RE: Planning Application: FG/97/21/HH 4 Florida Close, Ferring, West Sussex, BN125PF

We wish to make you aware of a number of strong objections that we have with regard to the proposed development 4 Florida Close, Ferring, West Sussex, BN12 5PF, As an immediate neighbour to the site of the property proposed for planning permission, we are of the view that the proposed development will have a serious impact on our privacy & impact us more broadly in a number of ways. Our specific objections are as follows:

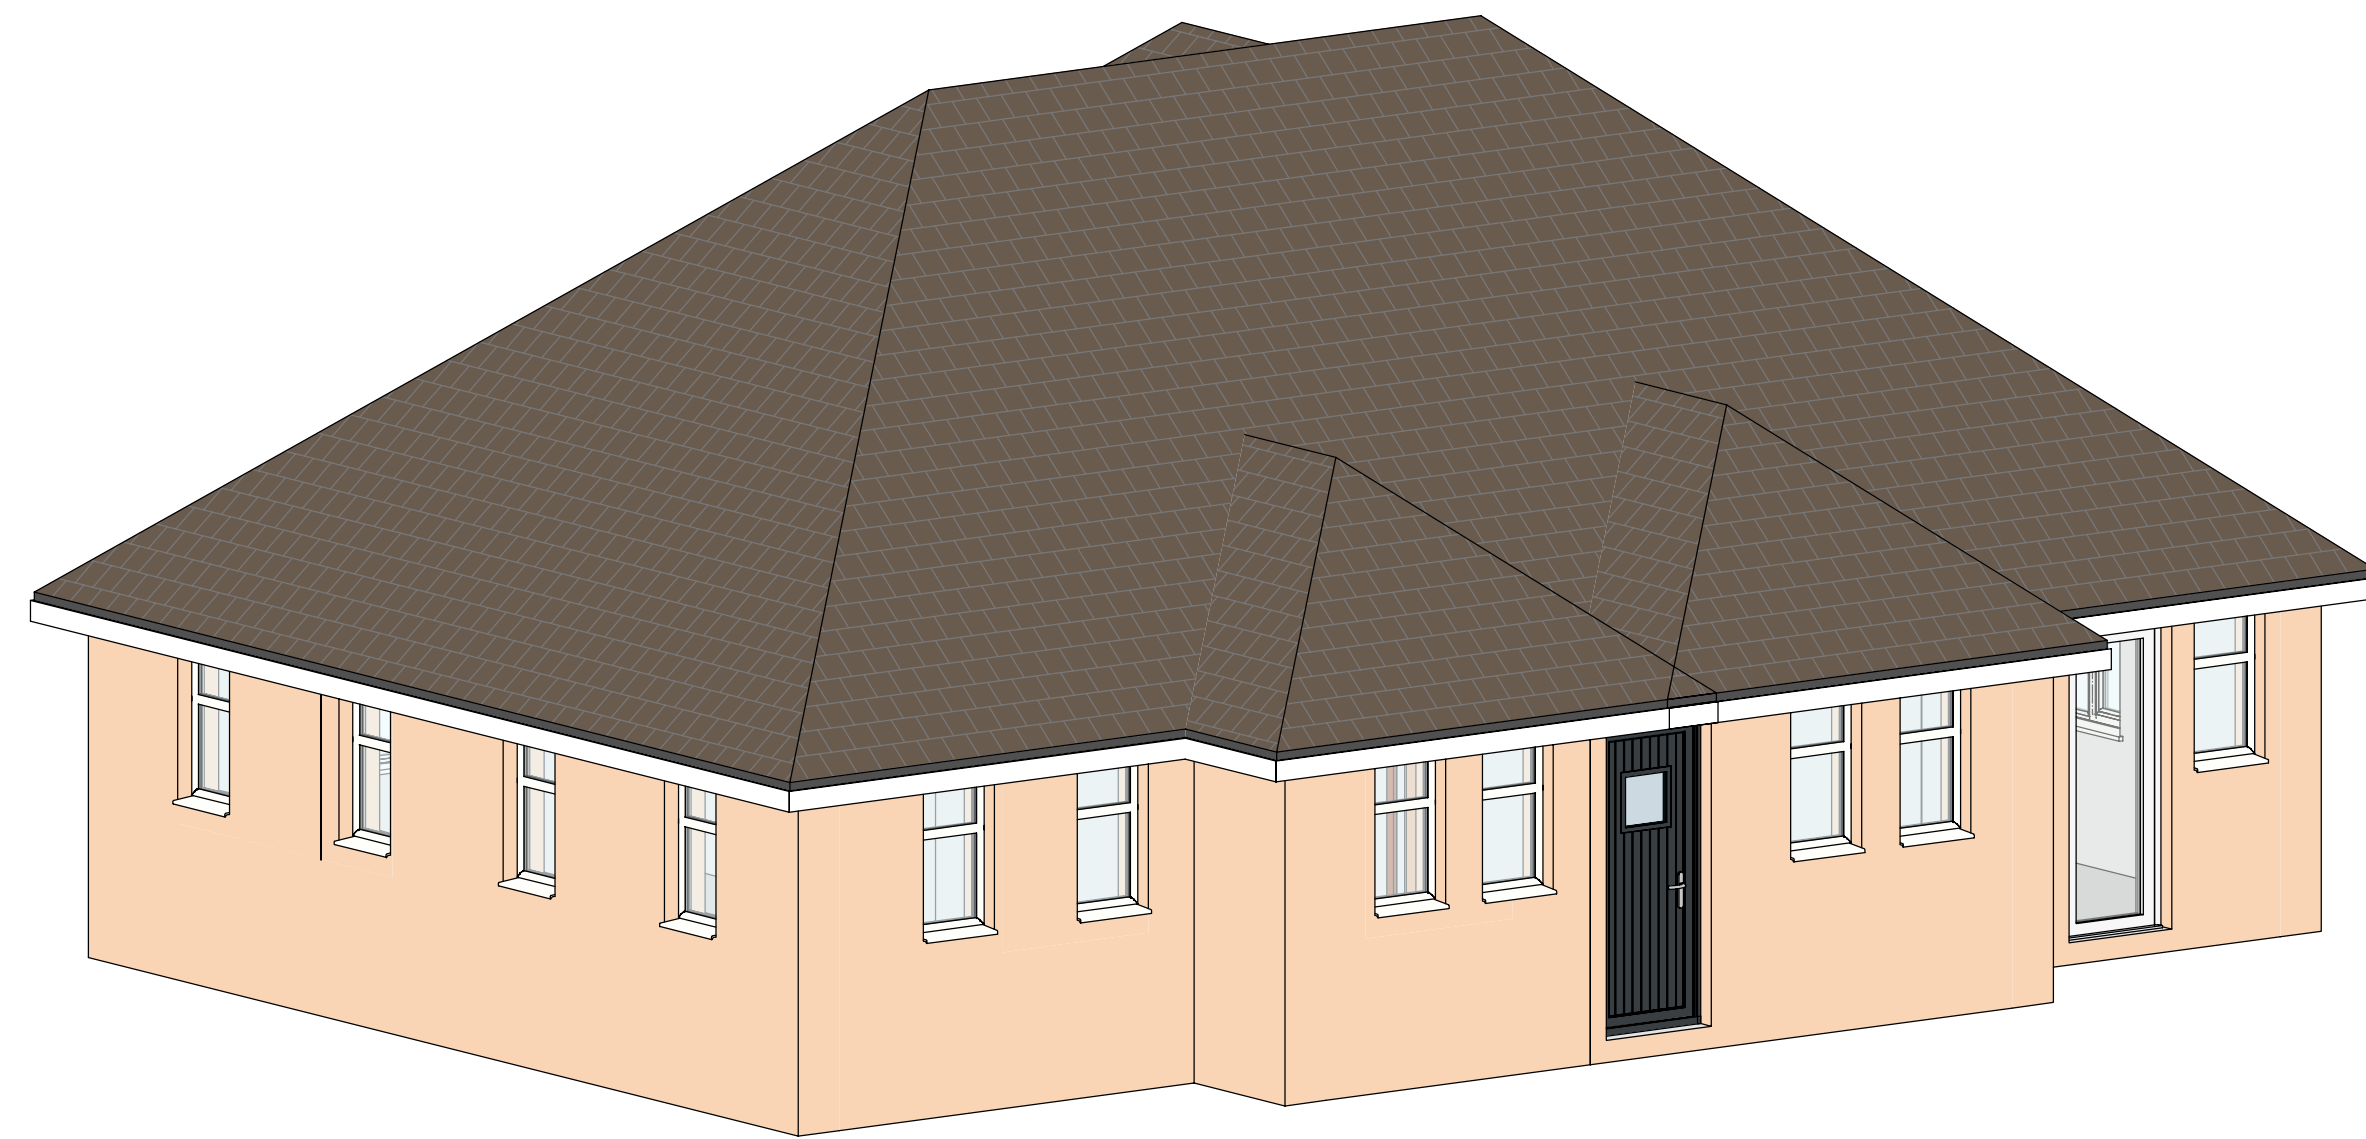
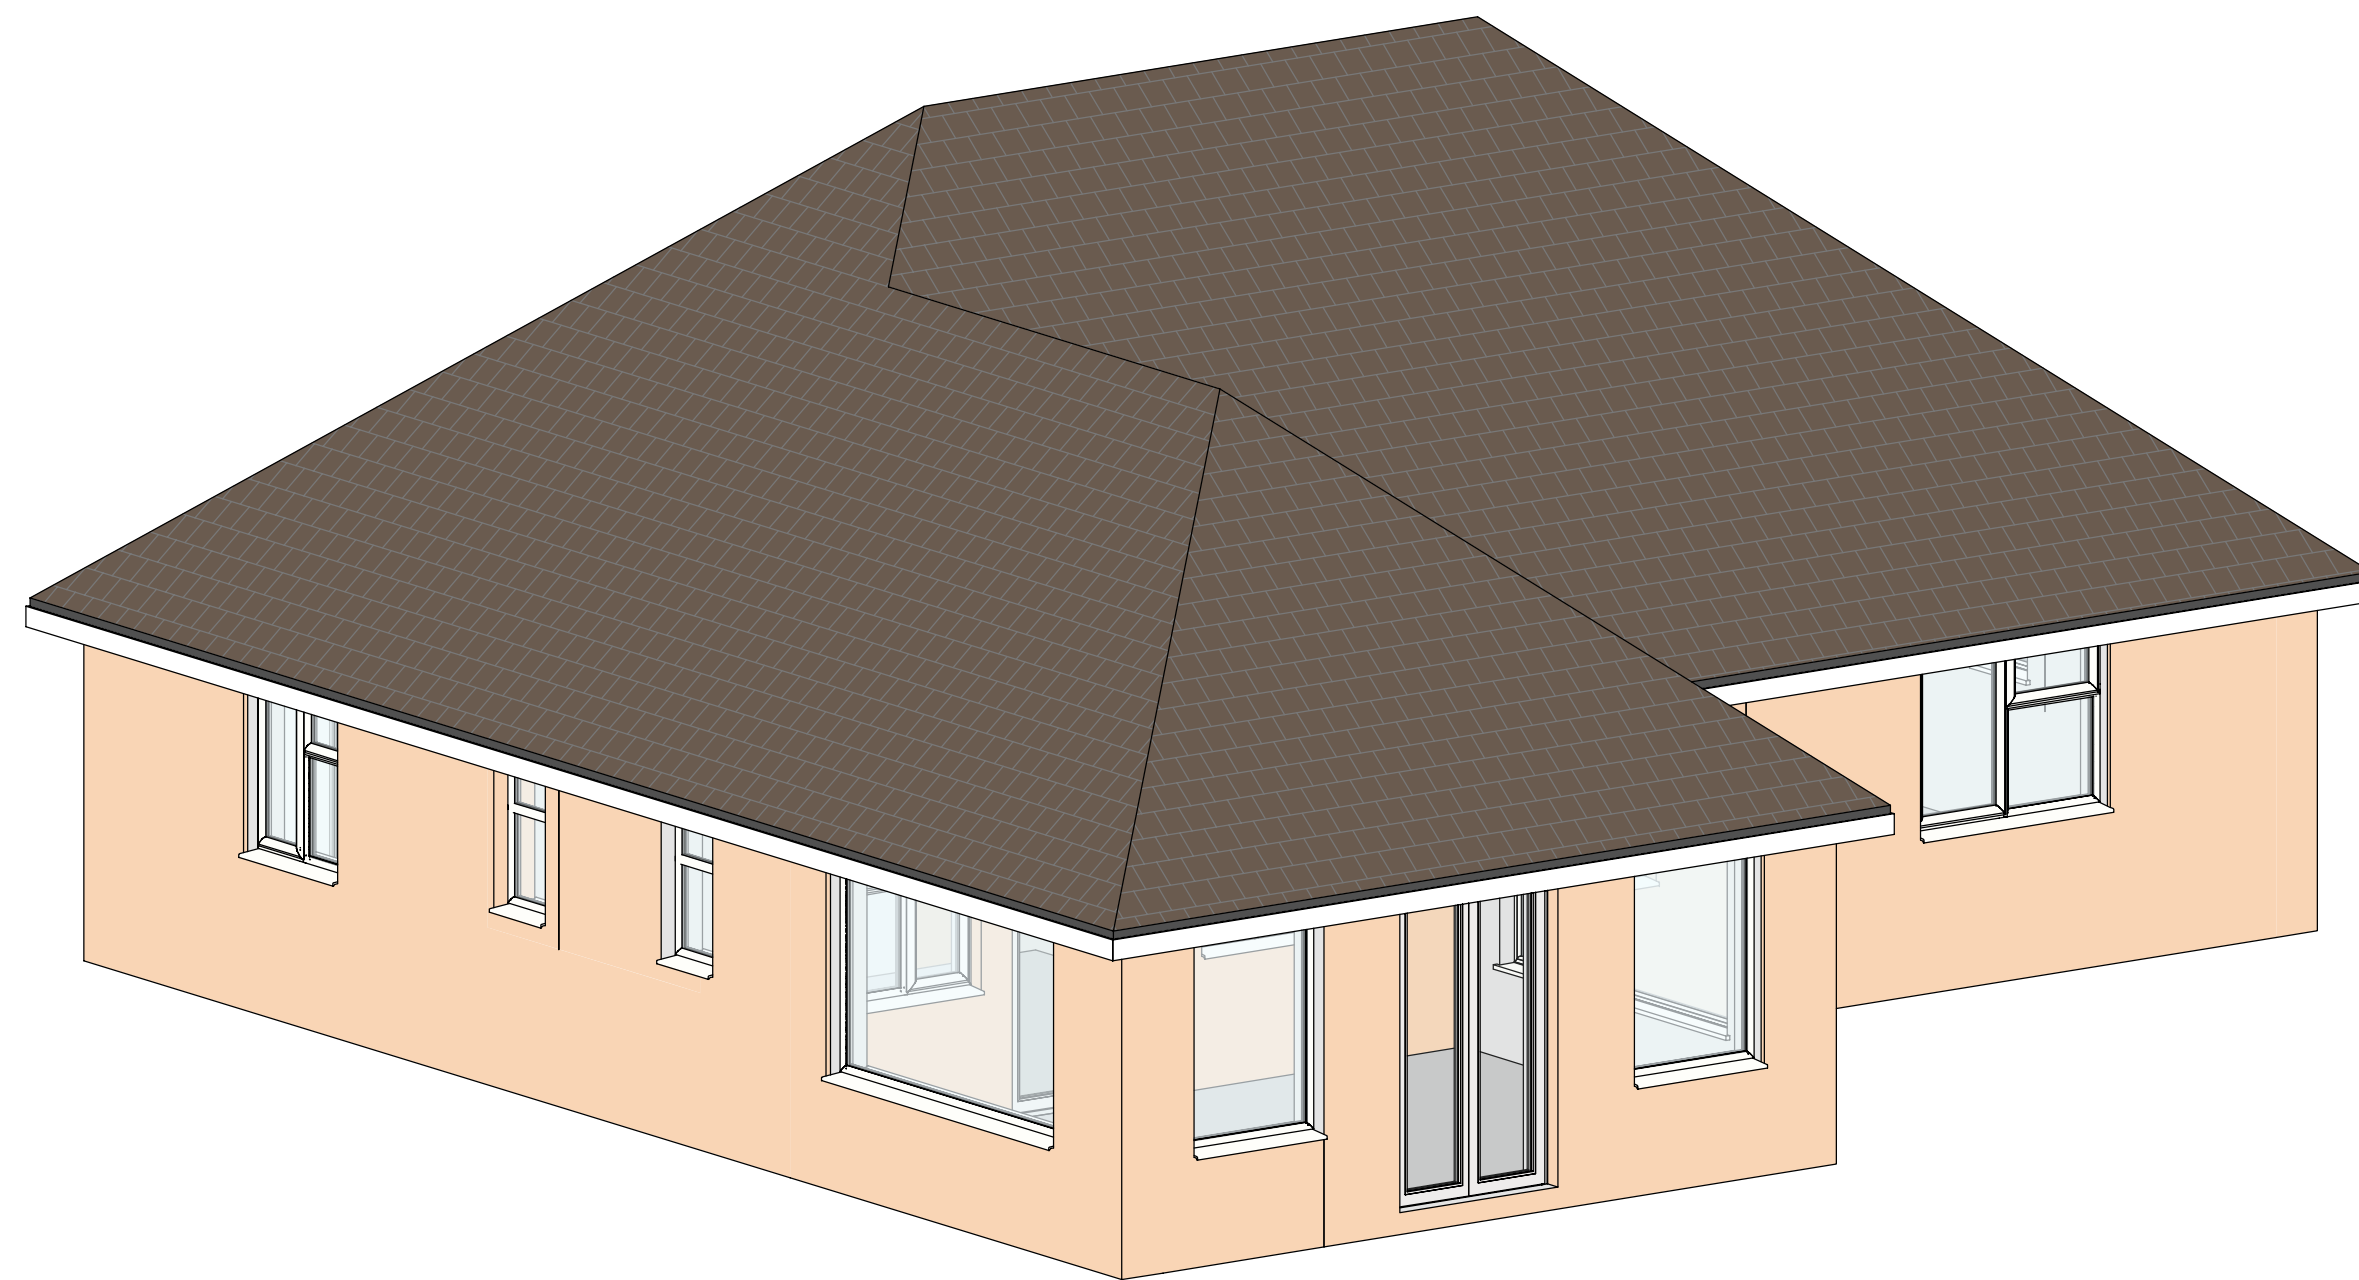
The developer is seeking approval to effectively rebuild the current dwelling. This means adding an additional floor to a property which is currently a bungalow with no current habitable living space in the loft to become a two-story property with five upper floor windows facing out to the front of the property. These windows, because of their positioning as per the "proposed front view", will overlook our property and provide for a view directly into our property, therefore removing our privacy in the following rooms;

Currently, no windows at the property that can see into our property or garden, therefore privacy is maintained and has been since the properties were built in the 1930's. Additionally, another proposed window to the west elevation will directly overlook our garden. Furthermore, the proposed addition of a glass balcony to the rear elevation will enable us to be completely overlooked. This is due to the design of the property and because of the addition of an extra floor - and position of the development. Currently, no windows exist that overlook our garden; therefore, privacy that has existed for almost a century will be lost.

Finally, the plans submitted do not show the distance from our boundary wall where the corner of the proposed study meets our property boundary. This is important because;

1. The proposed siting is less than ½ metre from our boundary and would include building a wall facing a current window that has been in place for 21+ years. This will remove our source of natural light and allow **no natural light into the room**. We would welcome a visit from the planning officer to illustrate this first - hand.
2. The siting of the proposed garage will remove our access to be able to maintain our existing telephone line – as the cabling runs into our house from the east wall of our property;
3. Critically, the main water supply to our house is fed by a pipe which runs from the developer's property straight to ours under where the proposed site of the garage will be built. This is the reason that the current garage is situated where it is and has been since the property was

1. be relocated away at least 2 metres from the boundary to enable us to maintain and make repairs to our property and enjoy natural light *and*
2. the developer re-routes any water pipes that feed our property to a place where they would be easily accessible to maintain and repair.
